Engineers Comments Regarding Surface Water Drainage

Application Reference:	FP/20/26/HH	Reviewer Reference:	ADC/KW/PC
Planning Officer:	Susan Haley	Date of Review:	18/03/2026
Site Name:	23 Kingsmead, Felpham		
Application Description:	Proposed single storey rear extension to existing dwelling, adjoining existing rear extension.		
Assessment Number:	1 of 1

Figure 1 – Flood Map for Planning (Flood Zones)

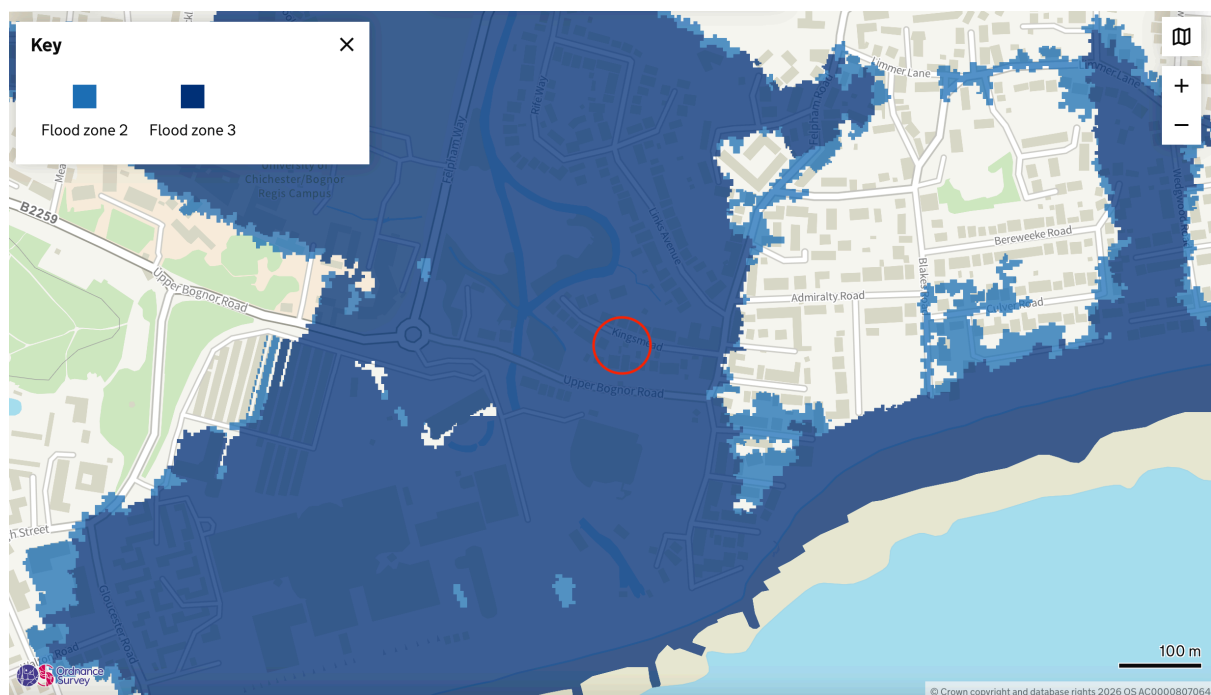
3.1. The site is currently located within Flood Risk Zone 3a, indicating a high probability of flooding. The submitted Flood Risk Assessment (FRA) has not provided robust or accurate hydraulic modelling to demonstrate the site's flood risk. It is not supported by product 4 data for the site which can be requested from the Environment Agency. It is important that this information is submitted as it will demonstrate accurately the flood risk on the site and its source. SuDS features should not be located in fluvial flood zones. (Please see our guidance relating to this at www.arun.gov.uk/surfacewater).

Figure 3 – Surface Water Flood Risk

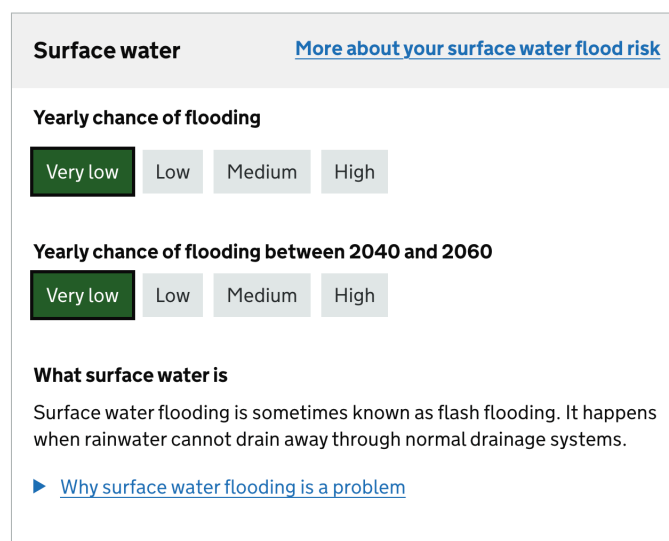
3.2. There is also a small pocket of low surface water flood risk at the very end of the rear garden. It is not expected that the proposed SuDS will be located in this area, however if the two areas do interact, this will need to be considered in any design. Please refer to Arun District Council's webpage for SuDS within Flood Risk areas for further details on the design requirements within these areas <https://www.arun.gov.uk/suds-in-flood-areas>.
